Add PCD File # PPR-2238 to all submittal documents

Site Development Plan_V1.pdf Markup Summary

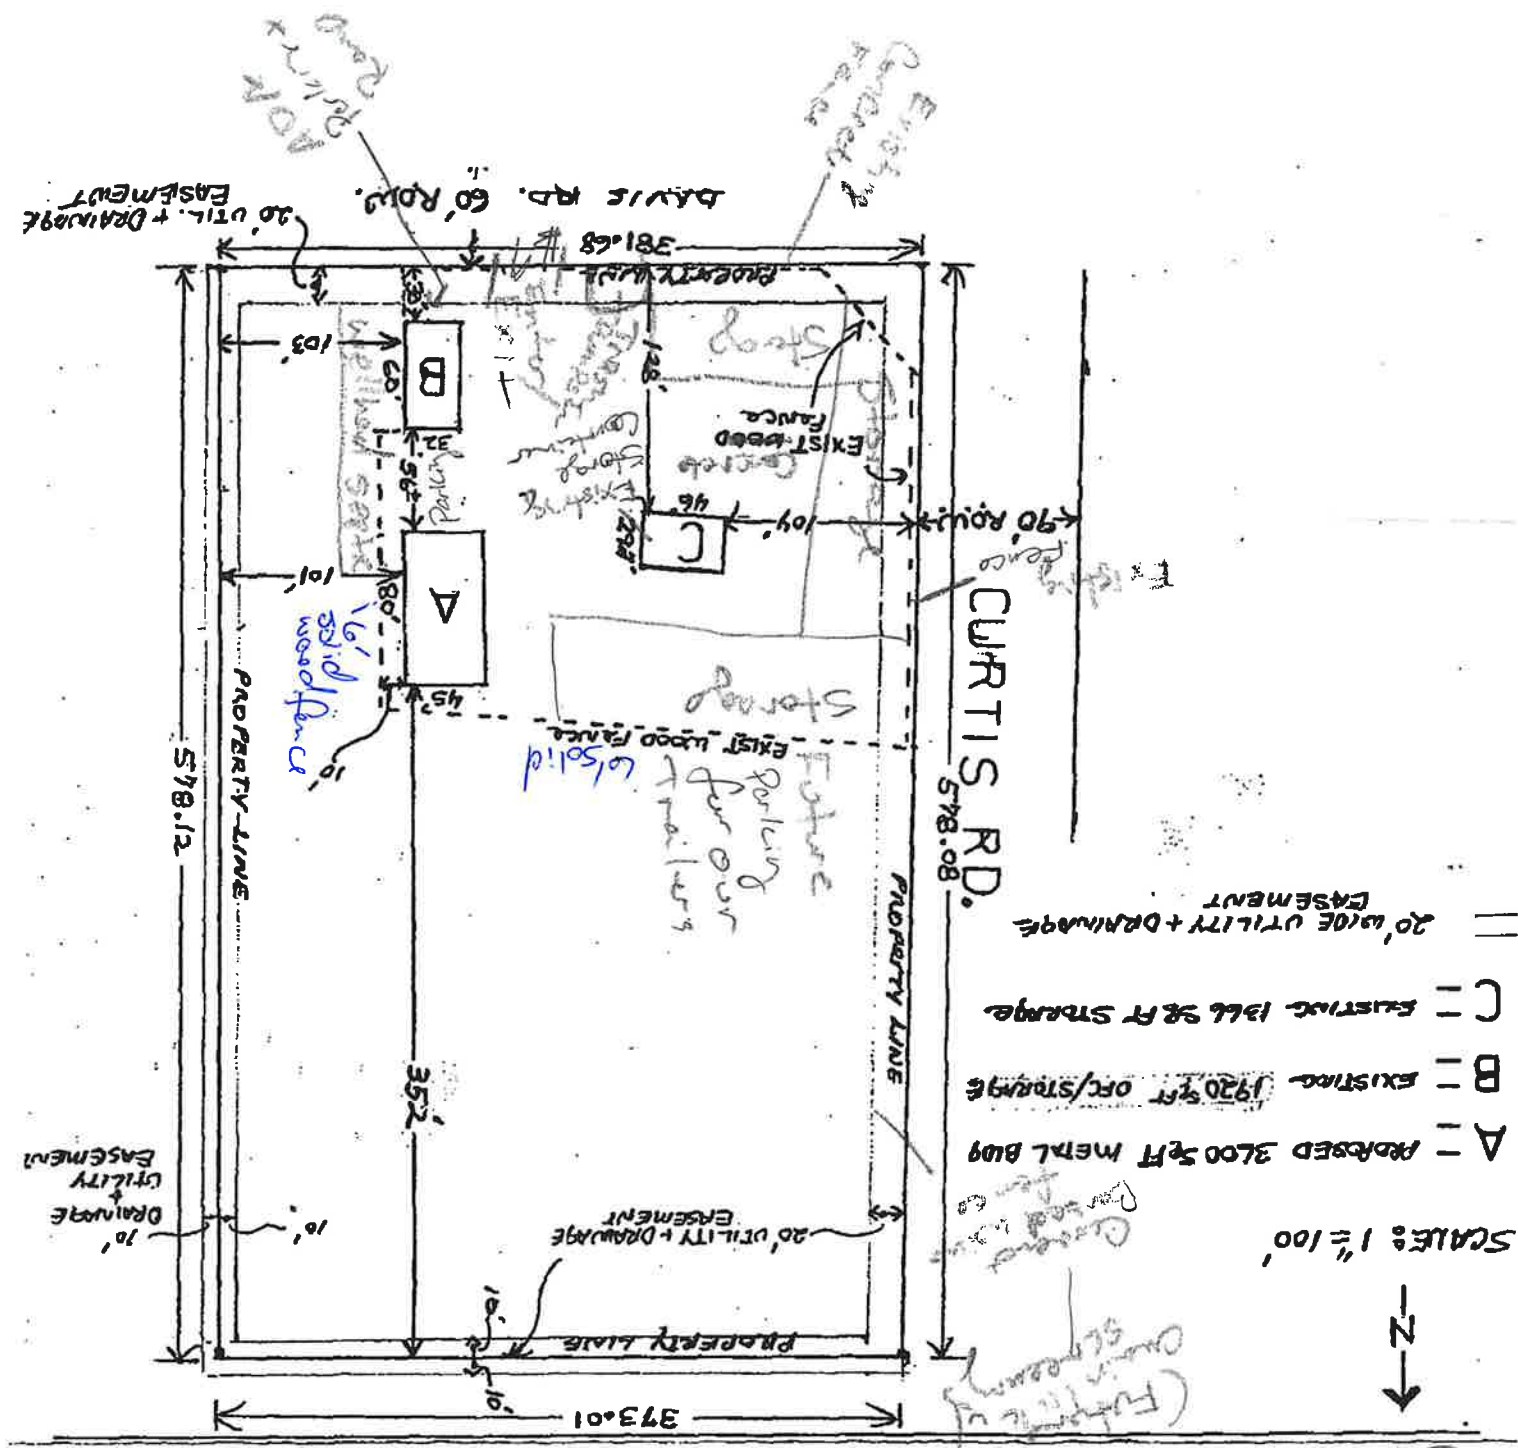
Add and label "ROW Preservation Line"

Future landscape screening? Please clarify.

Show opaque fencing for storage screening

Correct ROW to 180ft
The 2004 MTCP and 2016 MTCP call out a 4 lane principle arterial. This was listed BoCC Resolution 11-271 Rec # 211079062

Show utilities: existing & proposed

Show future R-O-W per Plat map

Missing Vicinity map

Missing Lighting & Landscape plan

Any new signage proposed at this time?

Show all existing parking & ADA stalls and any proposed - see checklist

Accurately show dumpster and screening
